**Consultation Response from: KC Environmental Health (Pollution & Noise Control)**
**2025/90450 - Land at, Blue Hills Farm, Whitehall Road West, Birkenshaw, BD11 2DU**
**Discharge of details reserved by condition 16 (Validation Report) of outline permission 2019/90527 for erection of up to 127 dwellings with details of access**
**Date Responded:**  
**14<sup>th</sup> March 2025**
**Responding Officer:**  
**NH**
**Responding Ref:**  
**WK/202505309**
**Condition 16 – Validation Report**

Windowless Sampling Borehole Works to Target Area of Former Bell Pits

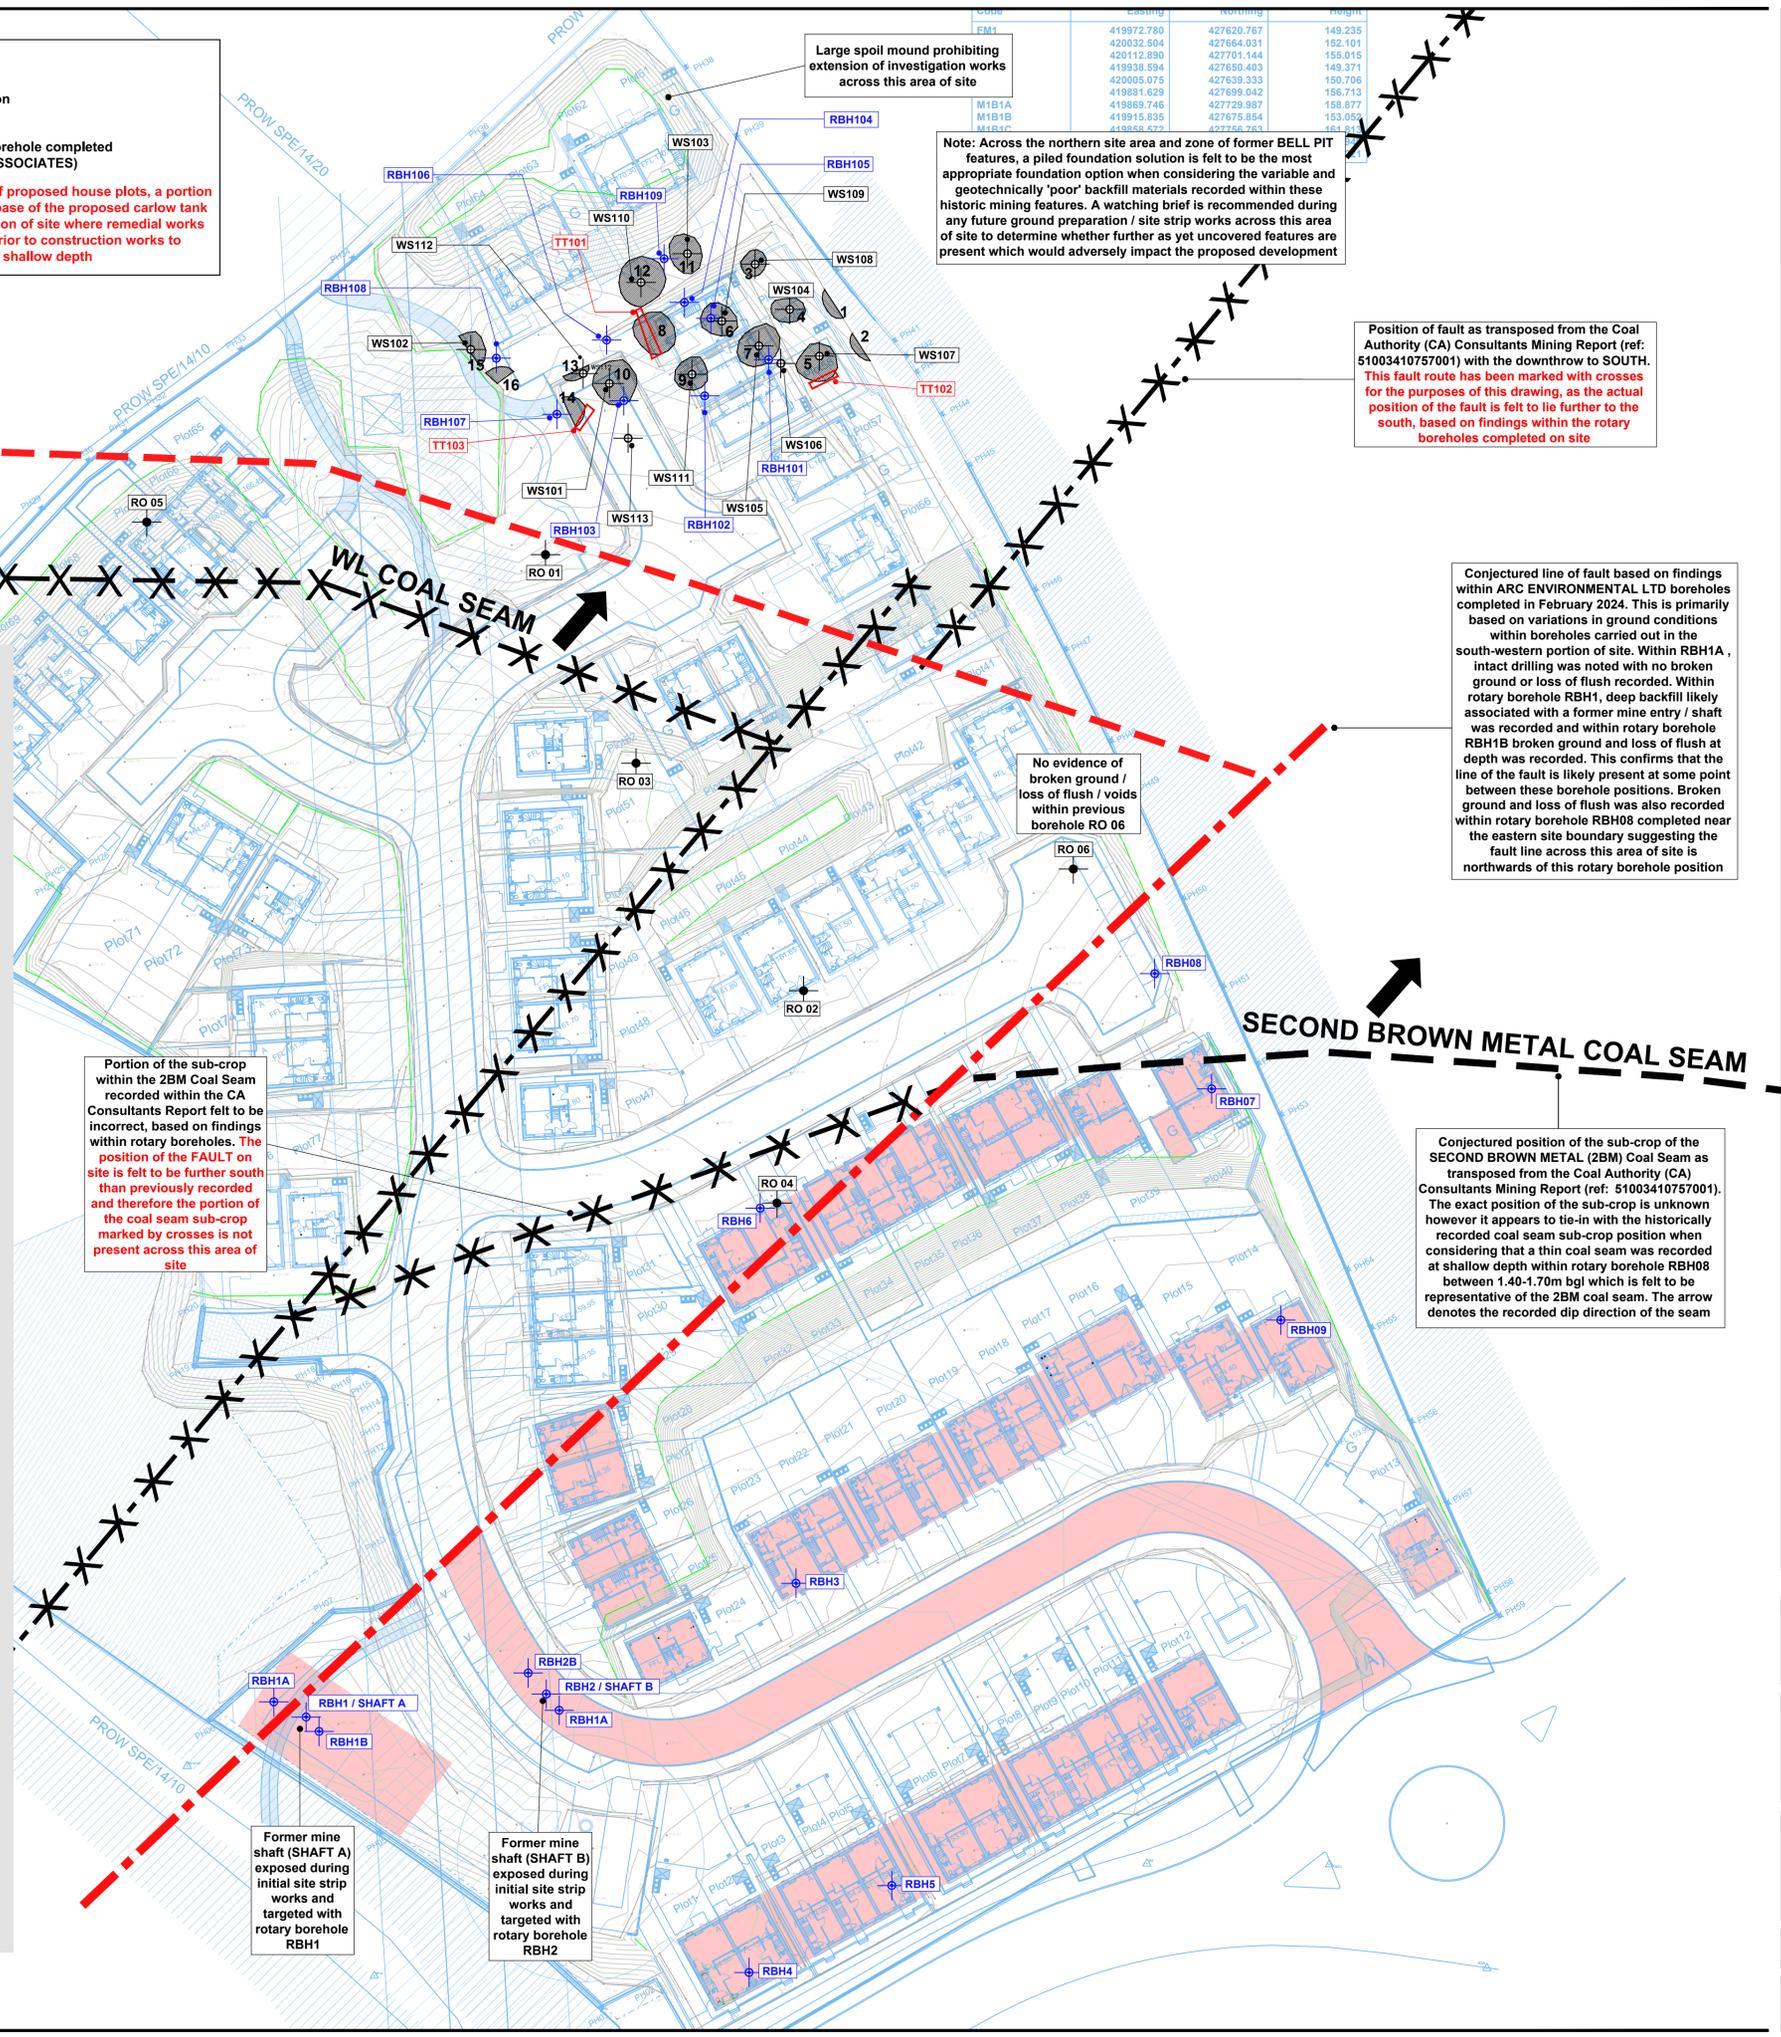
- (3) Supplementary Intrusive Ground Investigation Work Letter (22nd March 2024, 24-054.01L): This is geotechnical in nature. However, we request a revised risk assessment and conceptual model to confirm whether there is any risk to human health considering the findings.

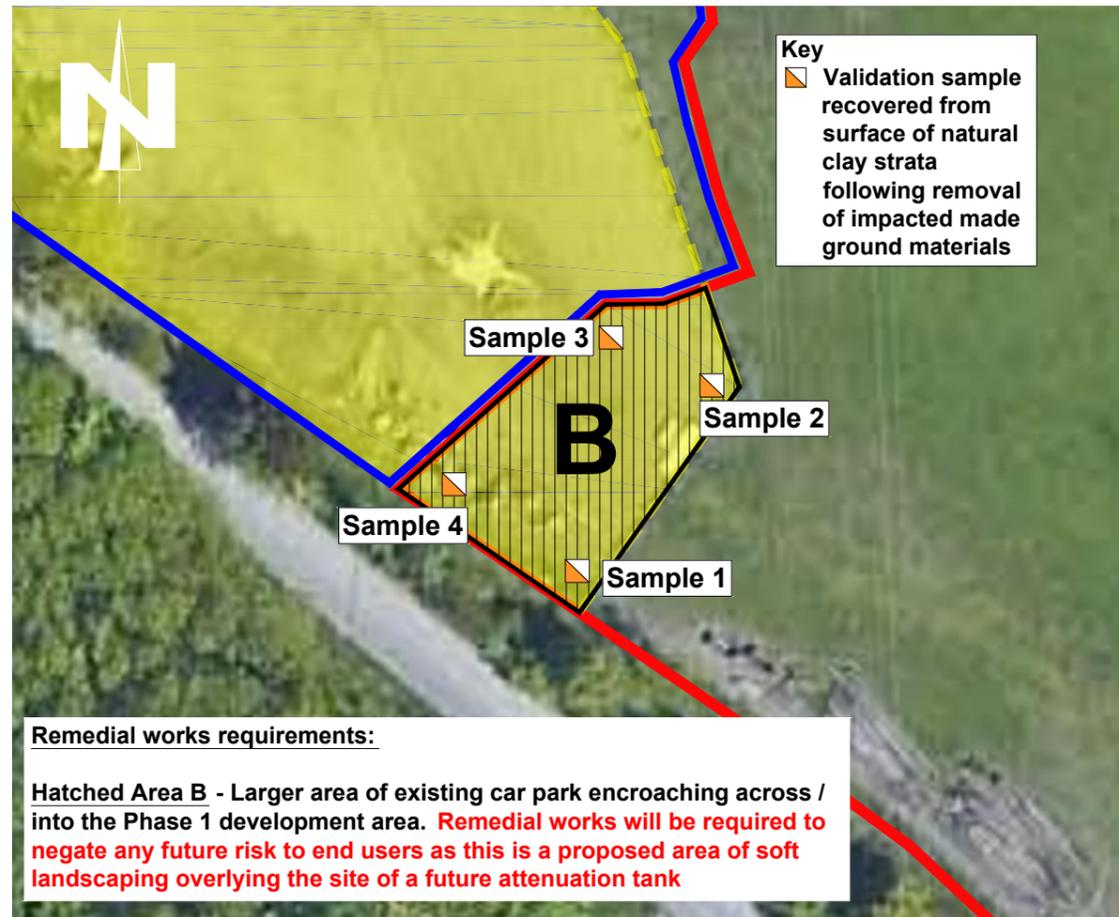
- (4) Validation of Hotspot Removal Letter (8th November 2024, 22-110.01L): Only four tests were undertaken on samples from four locations. We request additional commentary on the number of samples taken as this does not appear to be sufficient.
